Subject: Response To Application Number F/23/19/PL at Wicks Farm Ford Lane Ford BN18 0DF

WEST SUSSEX COUNTY COUNCIL CONSULTATION

TO:	Arun District Council FAO: Anita Gardner
FROM:	WSCC - Highways Authority
DATE:	27 January 2020
LOCATION:	Wicks Farm, Ford Lane, Ford, BN18 0DF
SUBJECT:	F/23/19/PL Variation of conditions 2-plans condition to show new site access & red edge & removal of conditions 13 & 14 following the grant of F/30/18/PL dealing with the use of an existing access instead of creation of new access.
DATE OF SITE VISIT:	n/a
RECOMMENDATION:	Advice
S106 CONTRIBUTION TOTAL:	n/a

**PROPOSED ACCESS
GENERAL ARRANGEMENT**

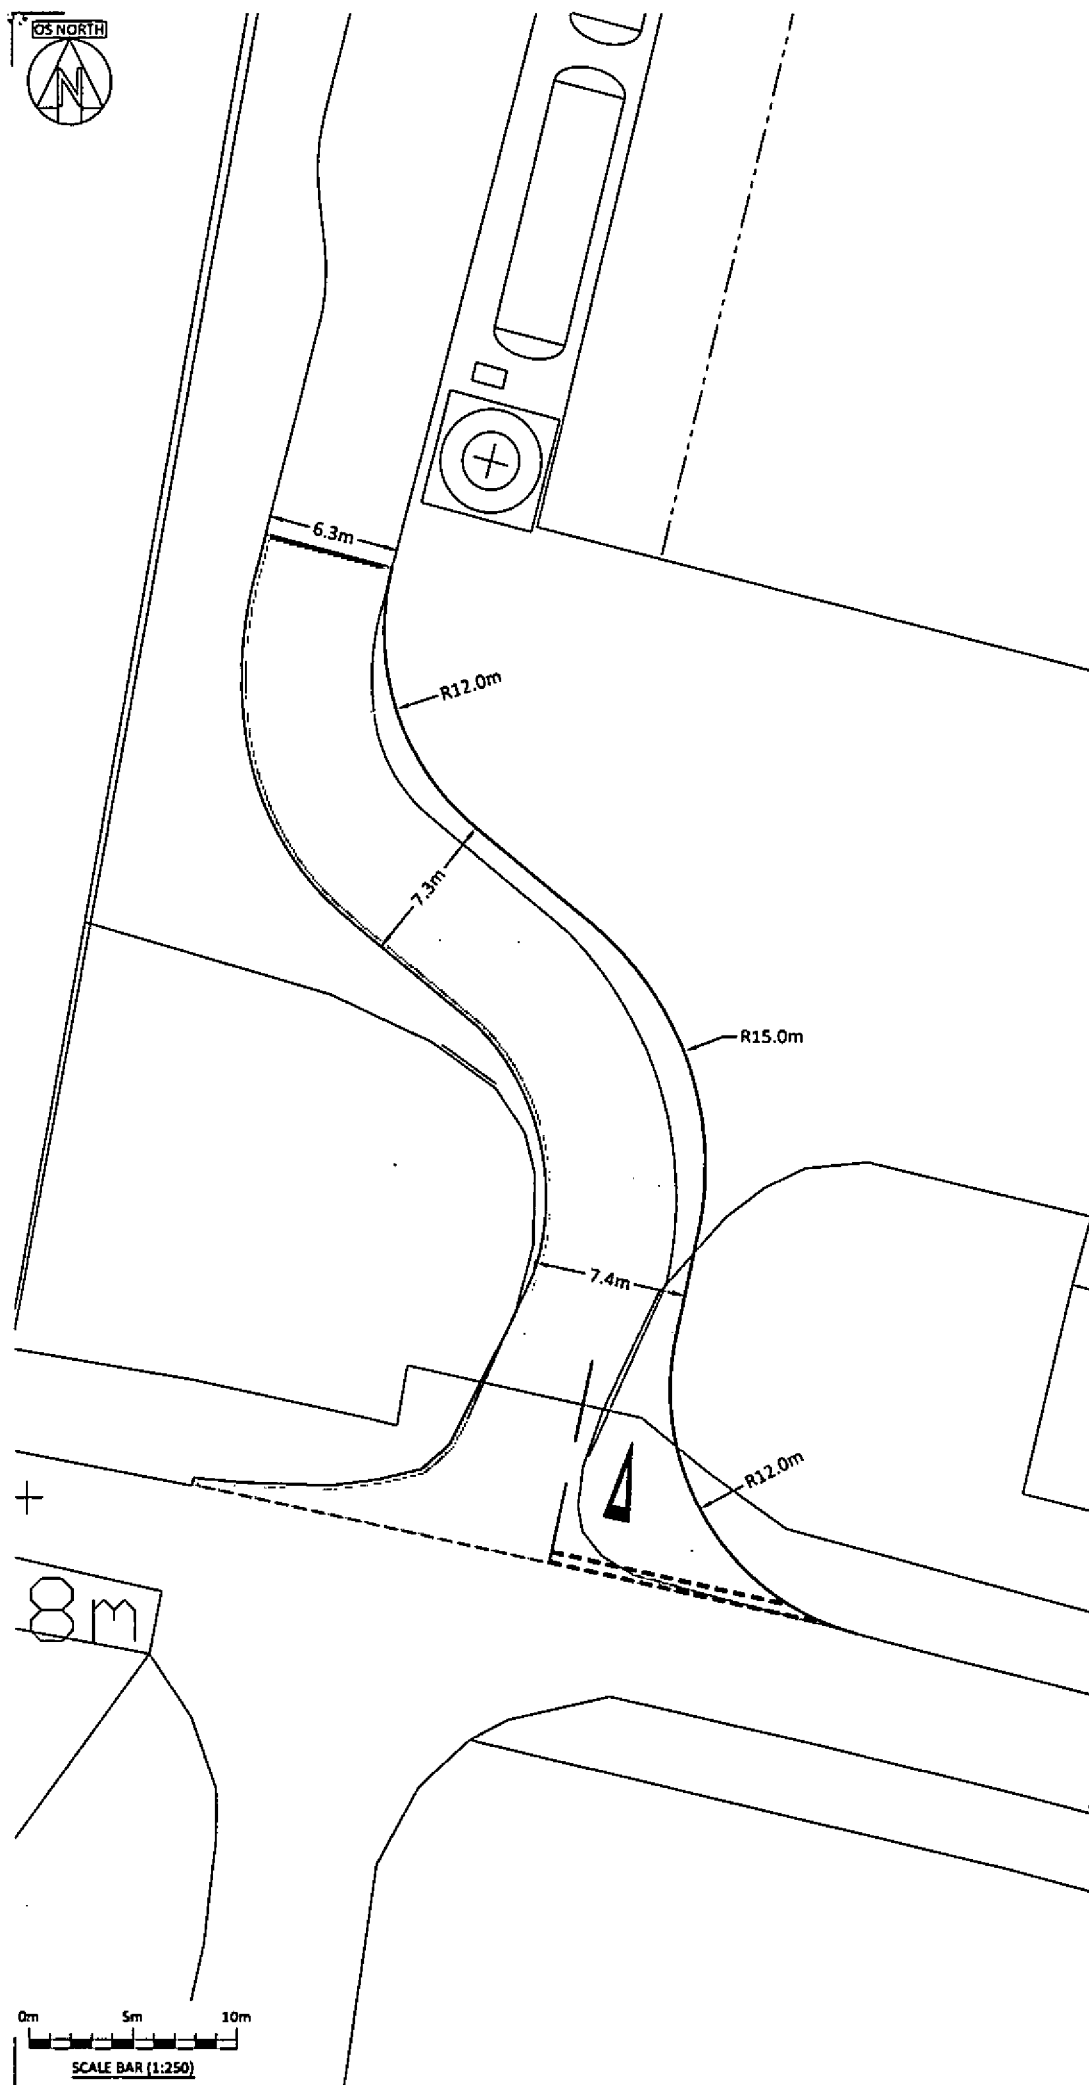
This application now seeks to utilise the access approved under WSCC/026/16 which was granted for use of extension of glasshouses and development of a digestate lagoon. The applicant has confirmed that the access approved under WSCC/026/16 has now been constructed to WSCC standards.

Whilst swept path tracking demonstrates that two HGVs can pass within the access of the site, the narrow nature and geometry of the access-way within the site prevents two HGVs from passing. It is acknowledged that there appears to be a passing place to the north of the access. To avoid conflict issues, the applicant has confirmed that HGV's will be scheduled to ensure that only one HGV is on site at any one time. The swept path tracking also indicates that a HGV can exit the site to the east while a smaller vehicle waits to enter off of the highway. The swept path tracking does

Drawing Title:
PROPOSED ACCESS VISIBILITY
SPAYS

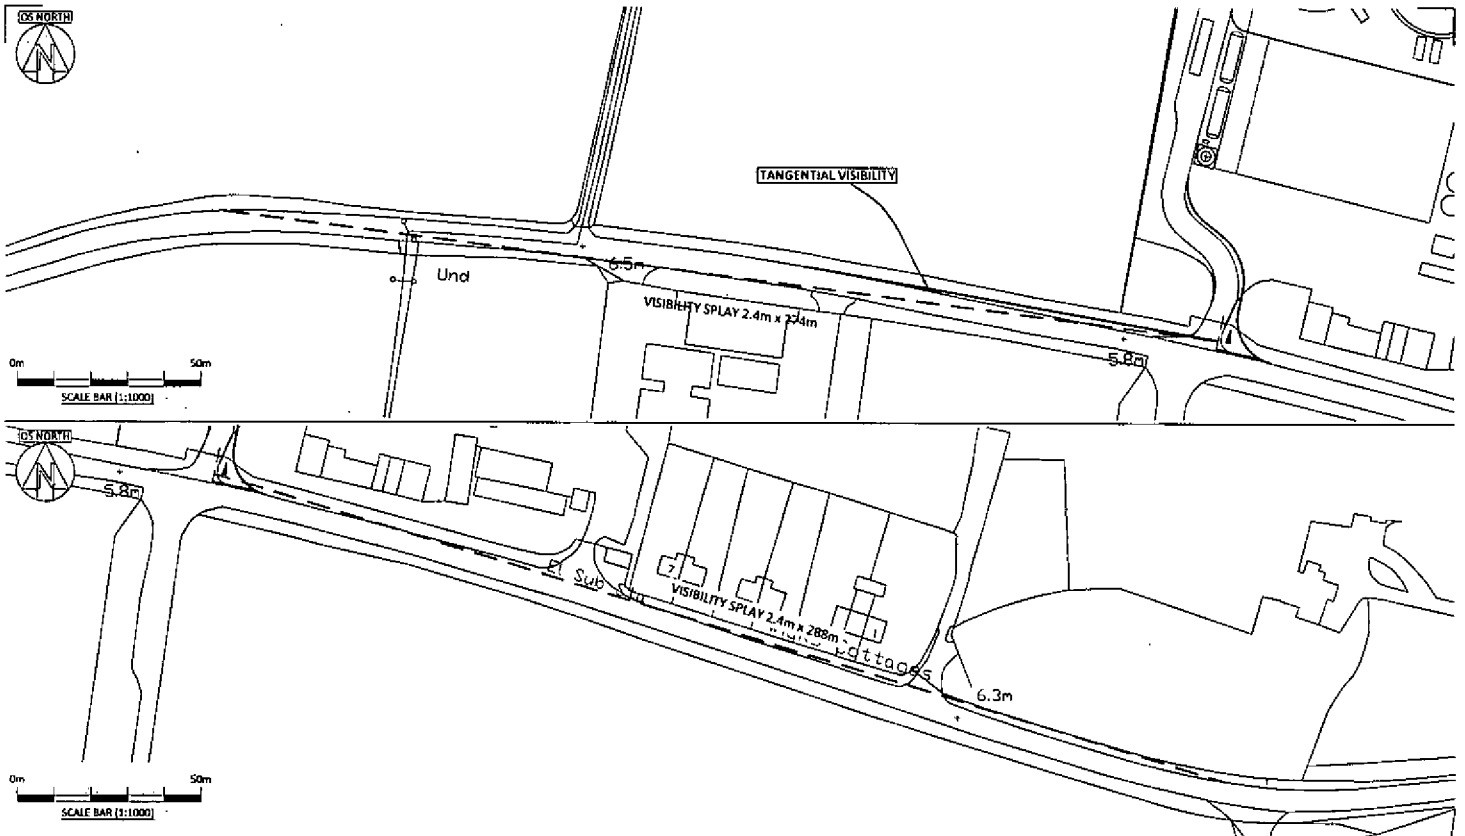
The application has been supported by a Technical Note (TN) by Stuart Michael Associates. The TN sets out that visibility splays of 2.4m x 274m to the west and 2.4m x 288m to the east are achievable at the newly constructed access. These splays exceed those required in accordance with vehicle speeds observed during a 7-day speed survey which revealed 85 percentile speeds of 44.5mph to the west and 45.5mph to the east (adjusted for wet weather speeds).
